Re: Responses to the following comments, EA Number EA1881, File Number AL2014:

Re: **File No. M-2018-063, Schubert Ranch Sand Resource, 112c Decision Letter - Financial and Performance Warranty Request - Construction Material Operation**

## **Revision to the submitted Mine Plan, September 9, 2019:**

REVISED: OCT 31, 2019 - 12:21:34

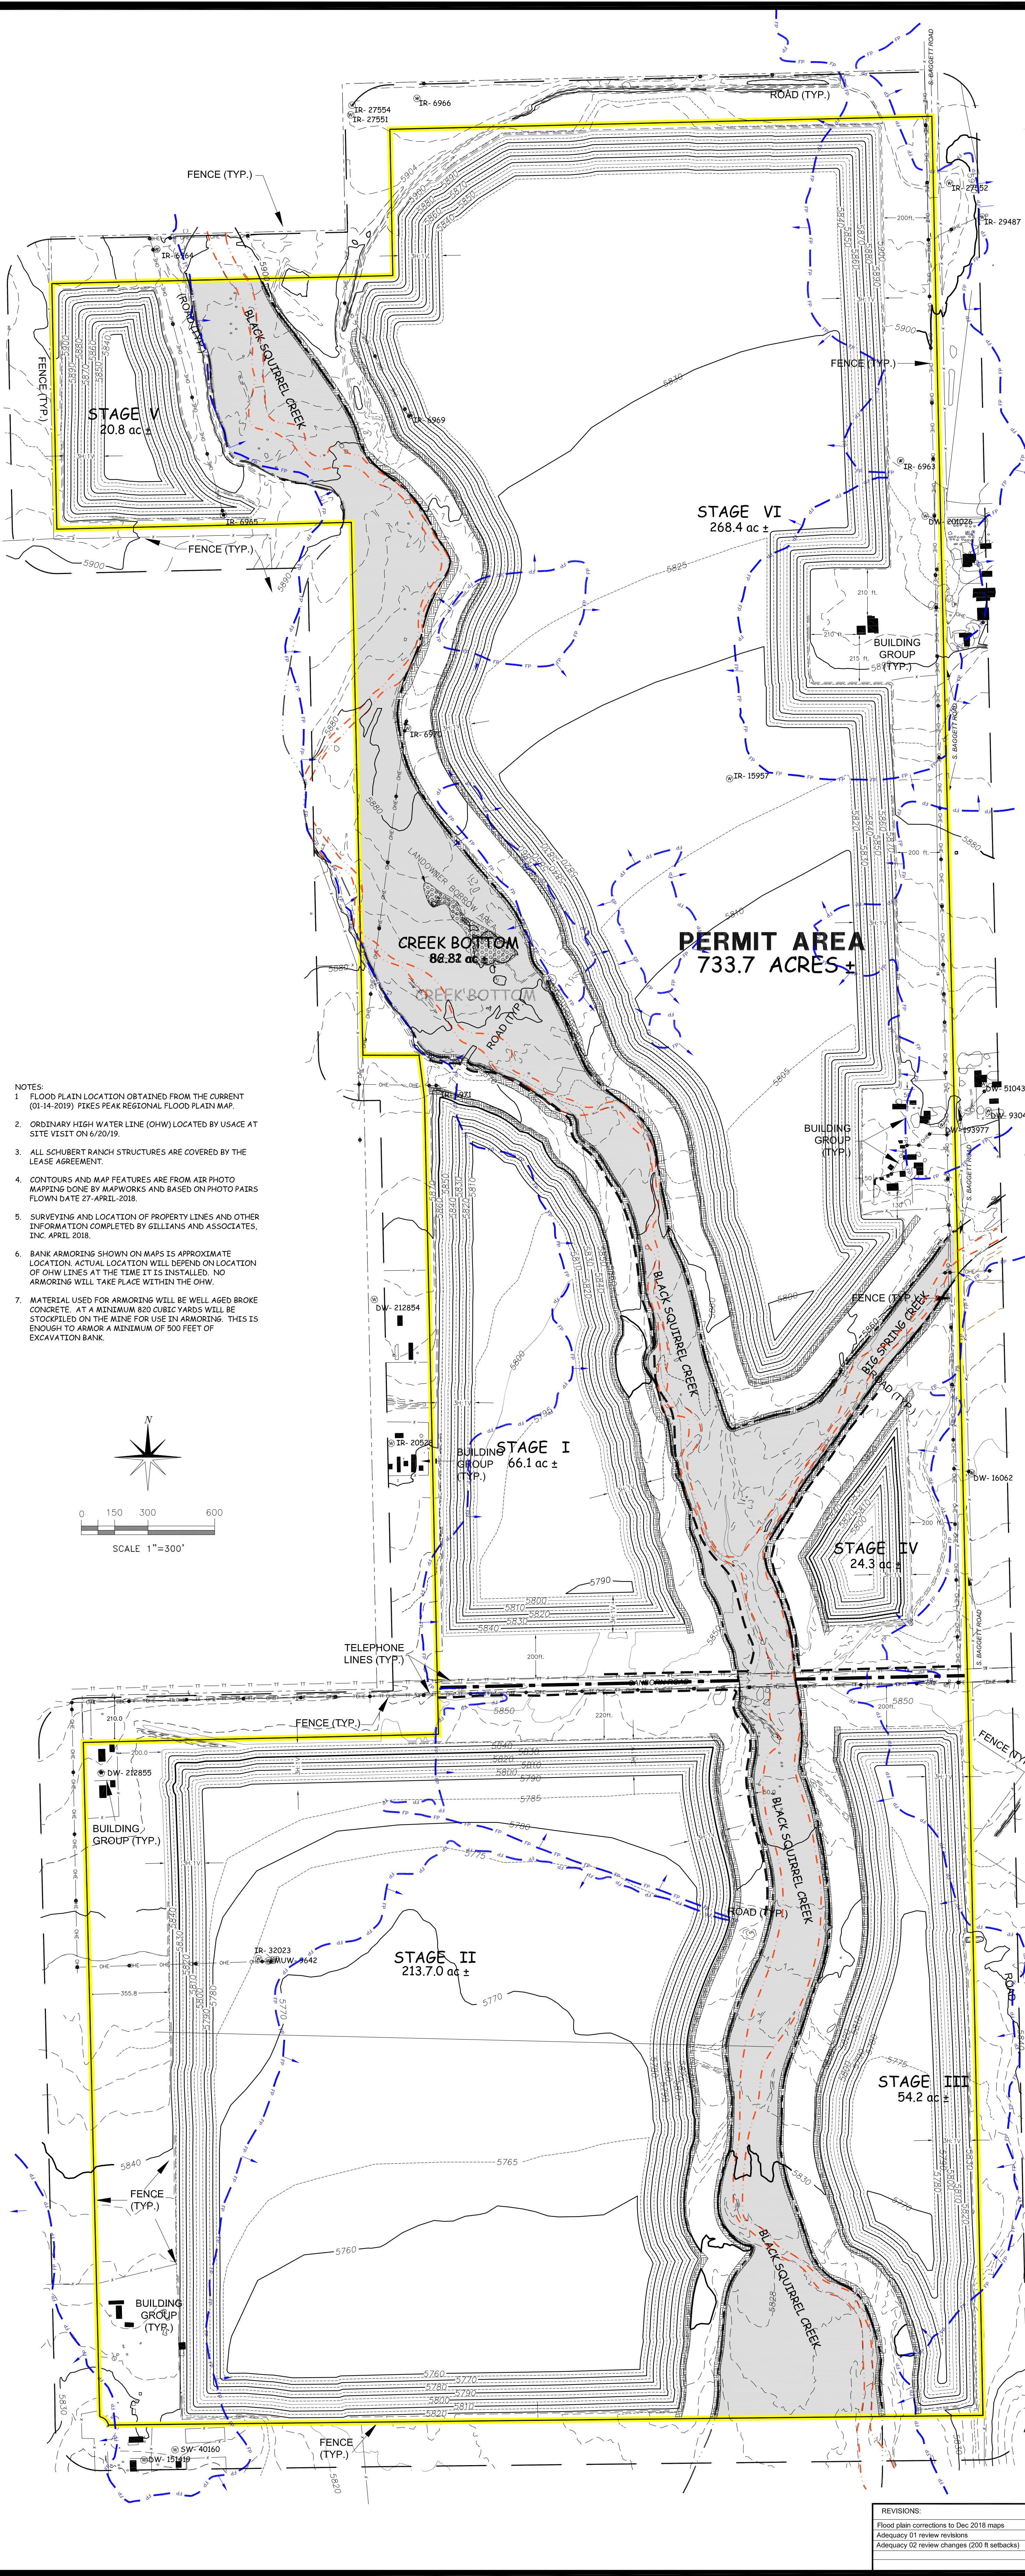
6. **Topsoil Stockpile Location:** The third paragraph on page 6 indicates topsoil may be stockpiled below grade such that it is screened below the surrounding areas. Should the pit flood during a 100-year event, the DRMS is concerned the flood waters might disperse the topsoil throughout the pit, making redistribution of this material for reclamation impractical

to impossible. Pursuant to Rule 3.1.9(1) please discuss why a below grade stockpile is preferred under these circumstances.

8. Ephemeral Drainages: The second paragraph on page 8 states the ephemeral drainages will not be disturbed by mining. Map C-1 shows mining to extend very near the Black Squirrel Creek and Big Spring Creek drainages. Furthermore, most of the mining is planned to be within the delineated 100-year floodplains. The DRMS is concerned that a 100-year flood event would erode the highwall next to the stream and as the pit is deeper than the stream invert, the stream would be captured by the pit and have not way to drain back into the drainage system. Pursuant to Rule 3.1.6, please describe how stream capture, considered disturbance to the drainage and the hydrologic balance, is to be avoided.

Initially that was to avoid placing an impediment to flood water flows across the surface and place them close to where they were needed for reclamation. But it never occurred to me that it might be a problem. I have revised the Map Exhibit C-1 - Mining Plan Map to show the soil piles will be placed around the perimeter of the excavated area. If they are located in the 100 year flood plane it will be on a temporary basis when the plan is to respread the soil on areas that are ready for resoiling in the near future and the piles will be aligned parallel to the ephemeral drainage.

It can't be avoided, only minimized during an unusual condition flood event. Under normal conditions there is no impact. As discussed in question 2, the propose mitigation is to install armoring along both side of the 150 foot wide berm adjacent to channel to protect the integrity of that bank. This is done so when the 100 year event ends the stream bed will remain intact and the location of the channel will not be diverted into the excavated area. The holes will drain naturally due to the nature of the sand strata along the creek and the fact that the water table is below the bottom of the mined area.
